TR010064: Application by National Highways for the M60/M62/M66 Simister Island Interchange Project

The Examining Authority's Written Questions and requests for further information

Issued on 17 December 2024

Drawing title
**LAND PLAN
REGULATION 5(2)(i)
KEY PLAN**

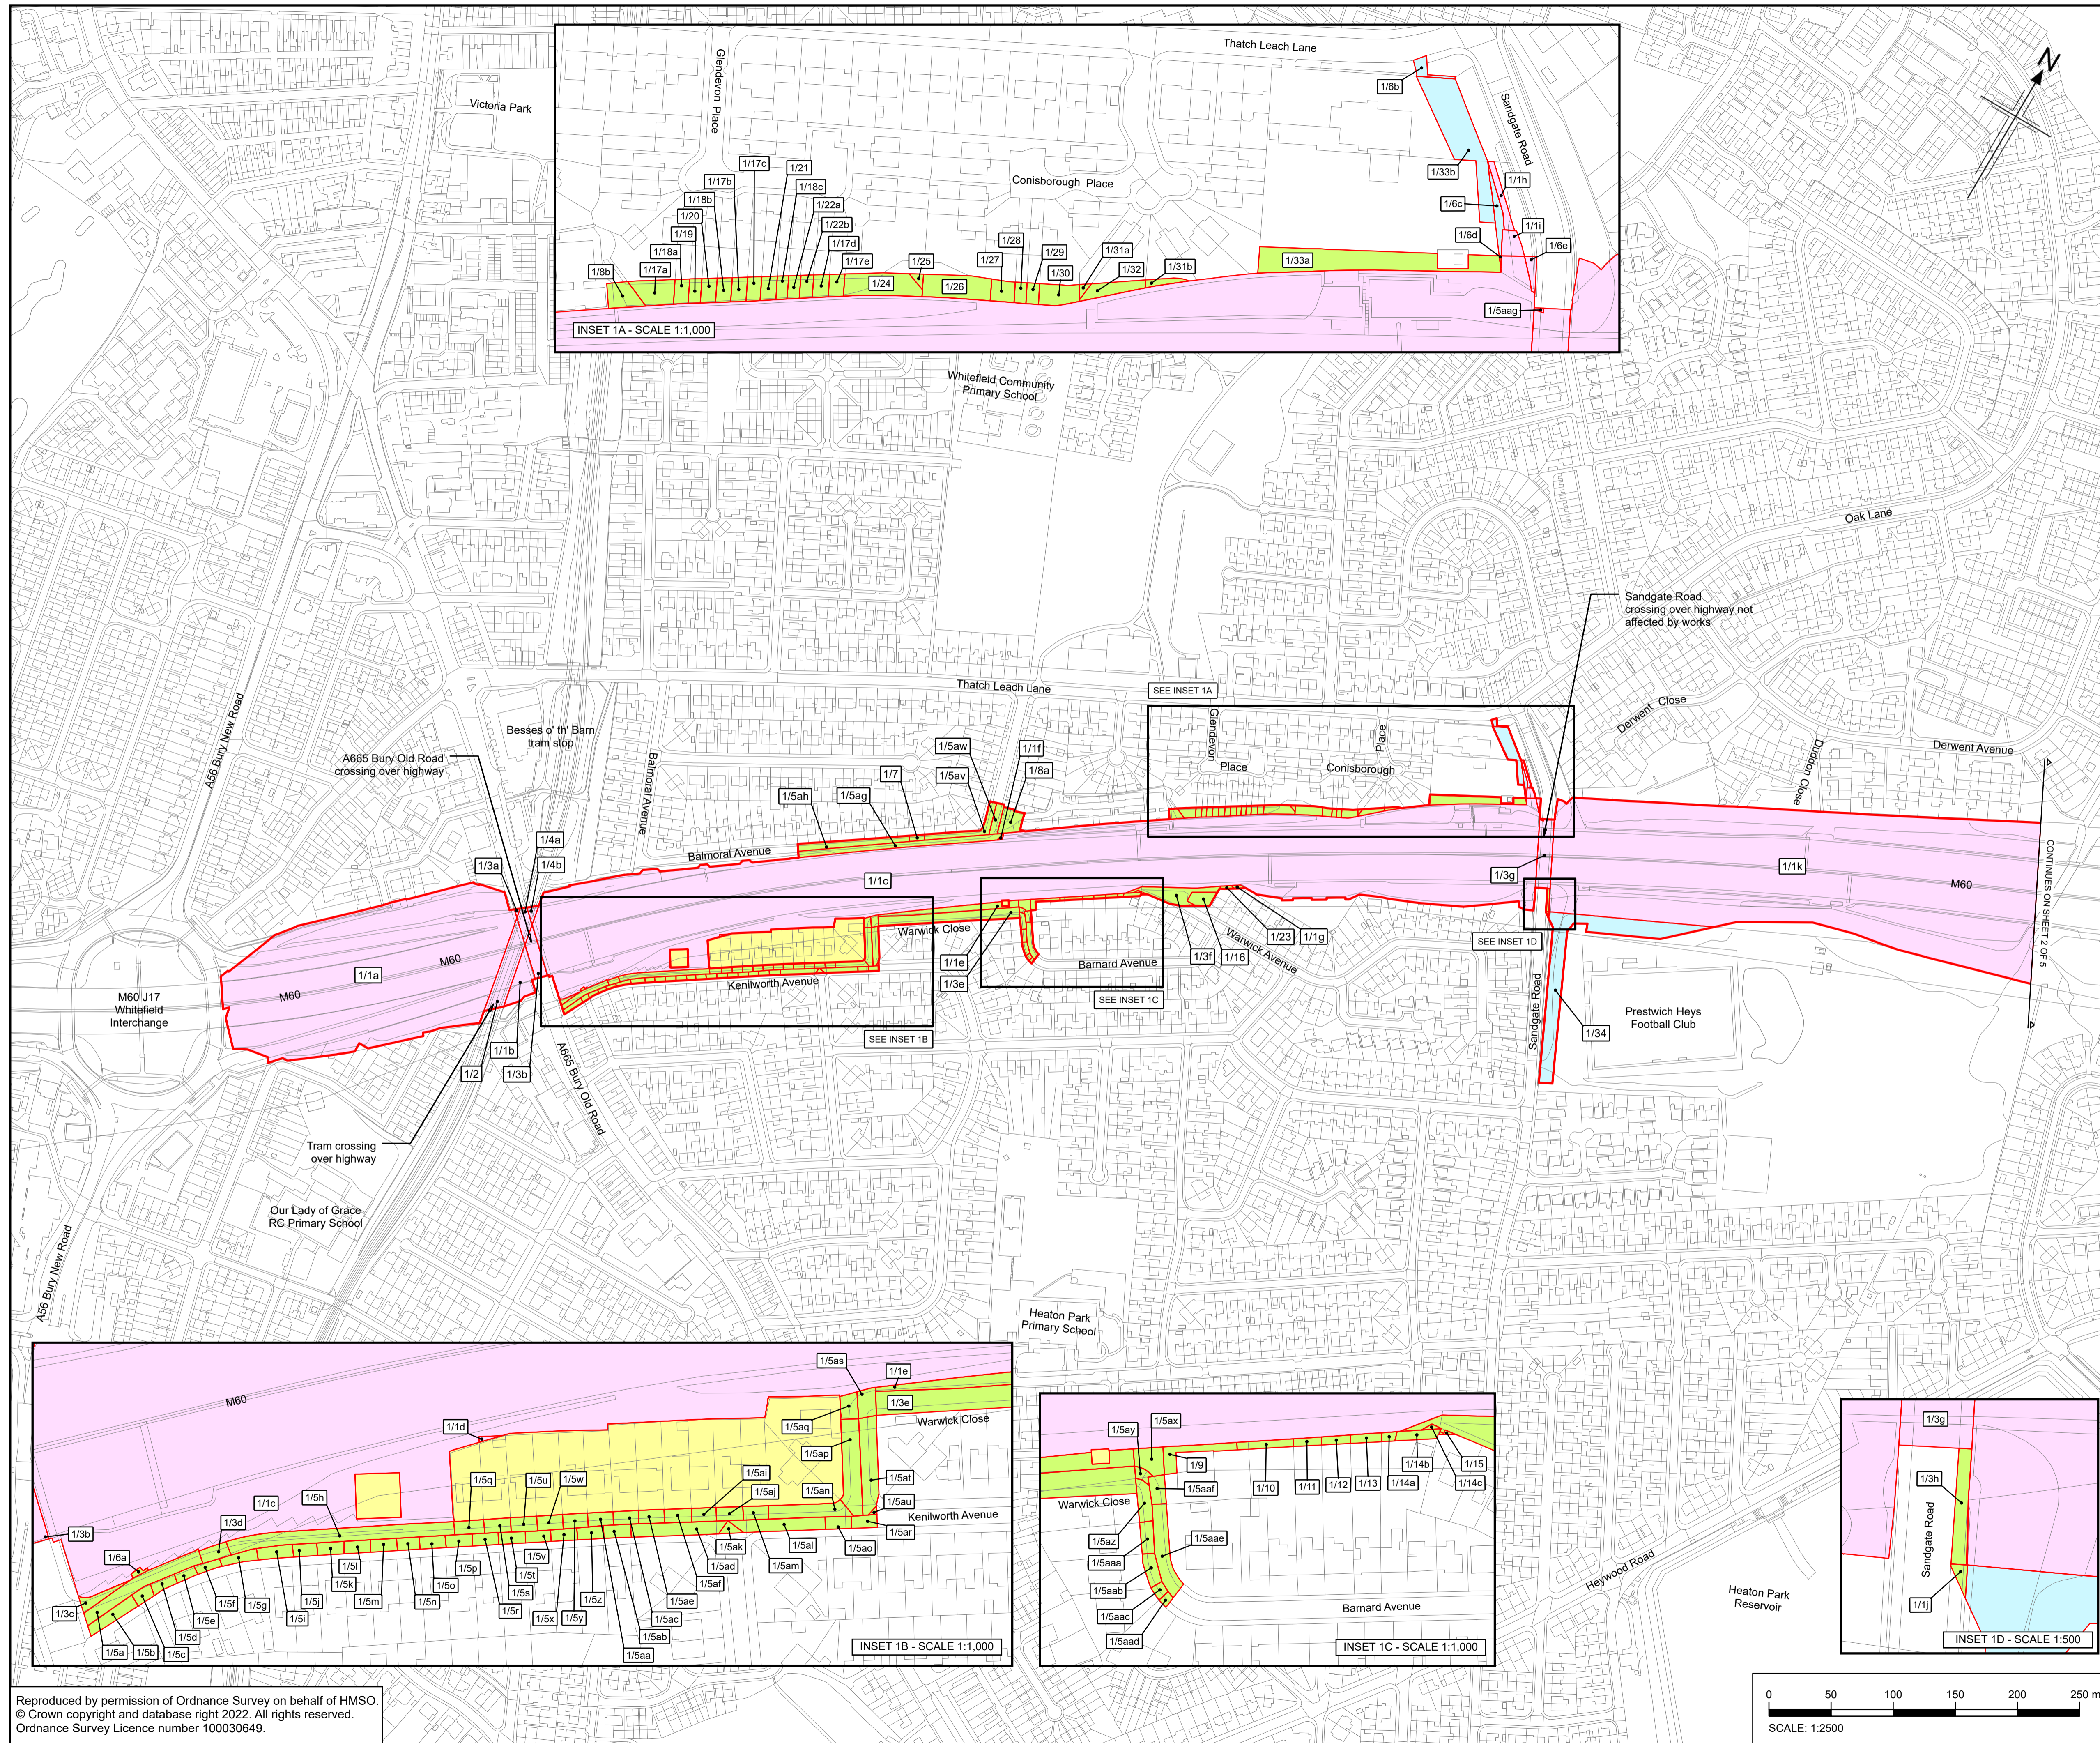
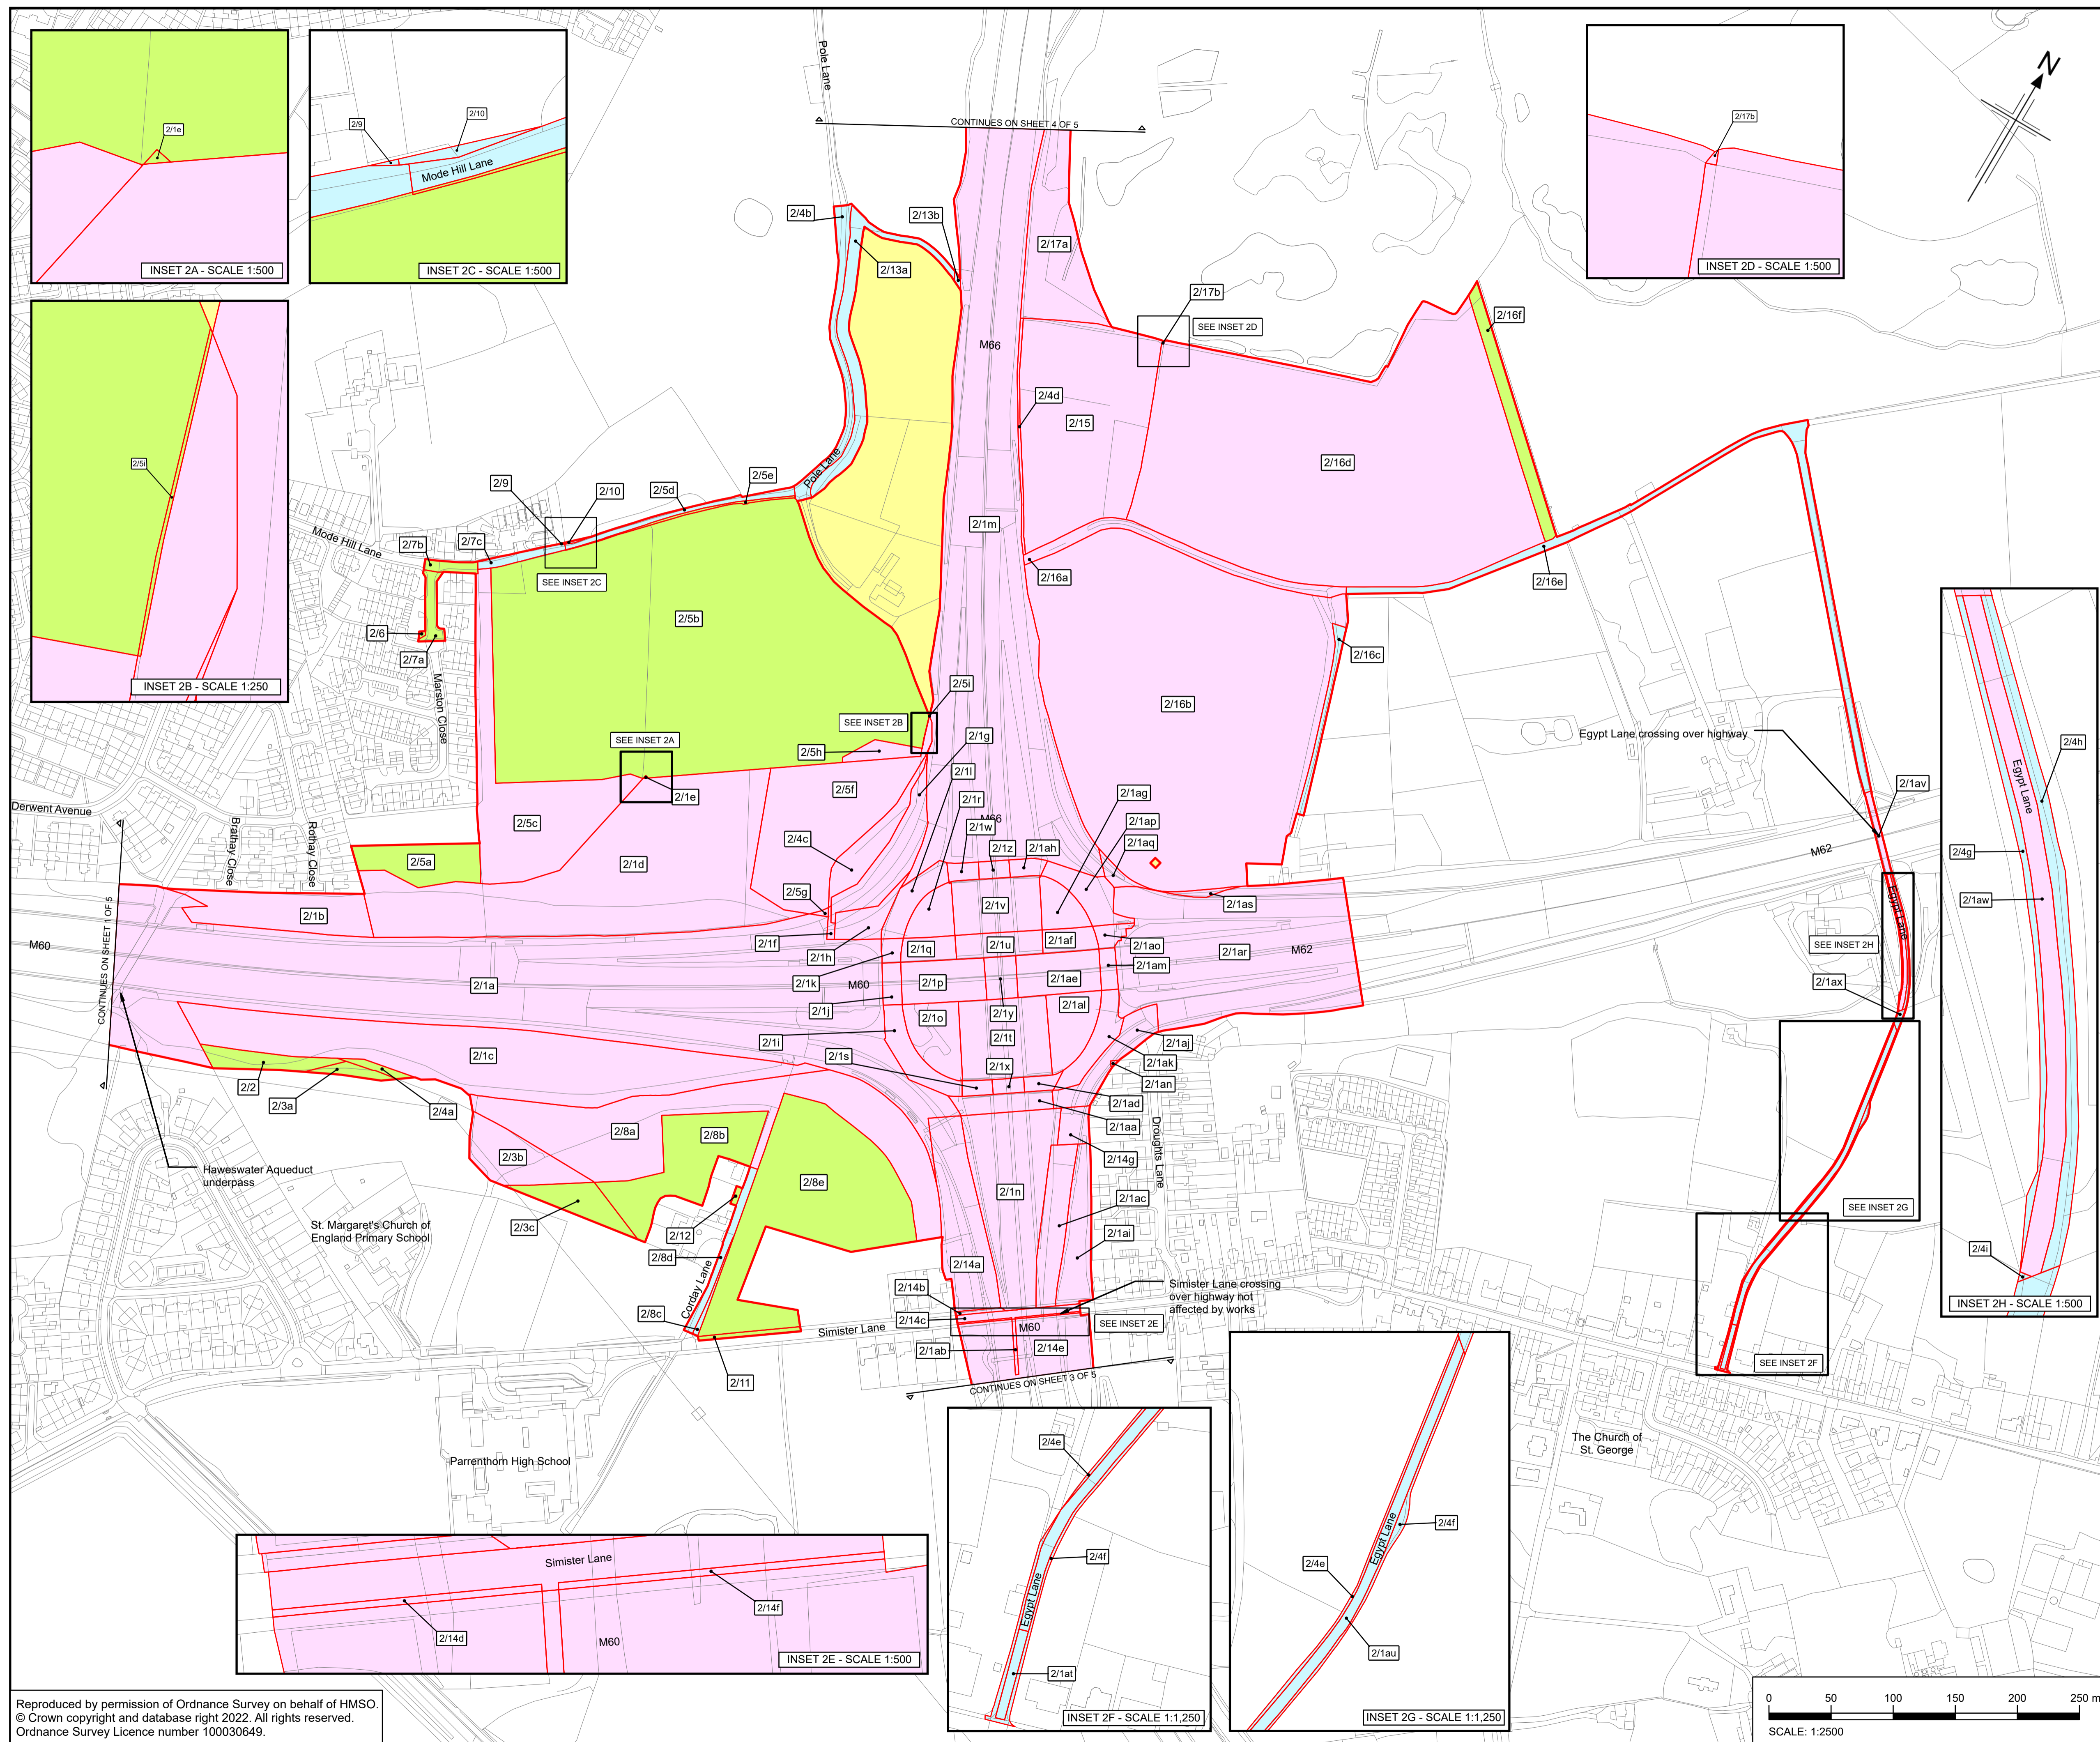
ExQ1	Question to:	Question
CA.2.2	Applicant	<p>Plot 4/2c and Plot 4/3</p> <p>Explain why temporary possession and permanent rights are being sought for both Plot 4/2c and Plot 4/3.</p>
CA.2.3	Applicant	<p>Crown Land</p> <p>With respect to Plot 4/3 please advise when it is expected that the necessary consent from the appropriate crown authority to the compulsory acquisition of its affected land will have been obtained.</p>
CA.2.4	Applicant, BMBC and Hillary Family	<p>Consultative Draft Northern Gateway Development Framework SPD and Relationship with Hillary Family Land</p> <p>The Hilary Family response [REP4-031] in paragraph 1.4 states “<i>The indicative masterplan for the Draft SPD indicates that all of the land in the ownership of the Hillary Family within the Order limits falls within the "potential developable area"</i>”. Conversely, the applicant’s response to BMBC’s response to ExQ1 CICE.1.3 in [REP4-027] on page 34 states “<i>The Applicant also notes that the draft masterplan does not include any development parcels on land affected by the Northern Loop proposal</i>”.</p> <p>Can the Hillary Family and applicant clarify their respective positions by signposting to where in the draft framework this is detailed.</p>

CA.2.5	Applicant	<p>Plot 1/1a</p> <p>In CAH1 the applicant explained that the whole of Plot 1/1a was within the ‘limits of highway deviation’ as indicated by pink shading on the Works Plans [AS-006]. The termination of the linear works (indicated by dumbbells) is shown on the Works Plans to be at the very eastern extent of Plot 1/1a. Explain why the entirety of Plot 1/1a is required for permanent acquisition, which includes carriageway beyond the termination of the linear works, and also land to the north and south of the M60 outside the existing slip roads and verge.</p>

ExQ1	Question to:	Question
CA.2.6	Applicant	<p>Plots 2/1aw and 2/1av</p> <p>In response to AP 5 from CAH1 it is stated <i>“To ensure that the Applicant can use Egypt Lane without constraint from any third-party interests, it has erred on the side of caution and included its own land as being subject to compulsory acquisition. This approach is consistent with the approach generally adopted by the Applicant in respect of the compulsory acquisition of its own land. It is also consistent with the approach adopted on other made DCOs.”</i></p> <p>Please supply detail of which made DCOs have used this approach.</p>
Cumulative and In Combination Effects		
CICE.2.1		<p>Nationally Significant Infrastructure Projects: Advice on Cumulative Effects Assessment</p> <p>Updated advice on cumulative effects assessment was published on 20 September 2024, replacing PINS Advice Note 17. Advise whether the updated advice has any implications for the assessment of cumulative effects in ES Chapter 15 [APP-075].</p>
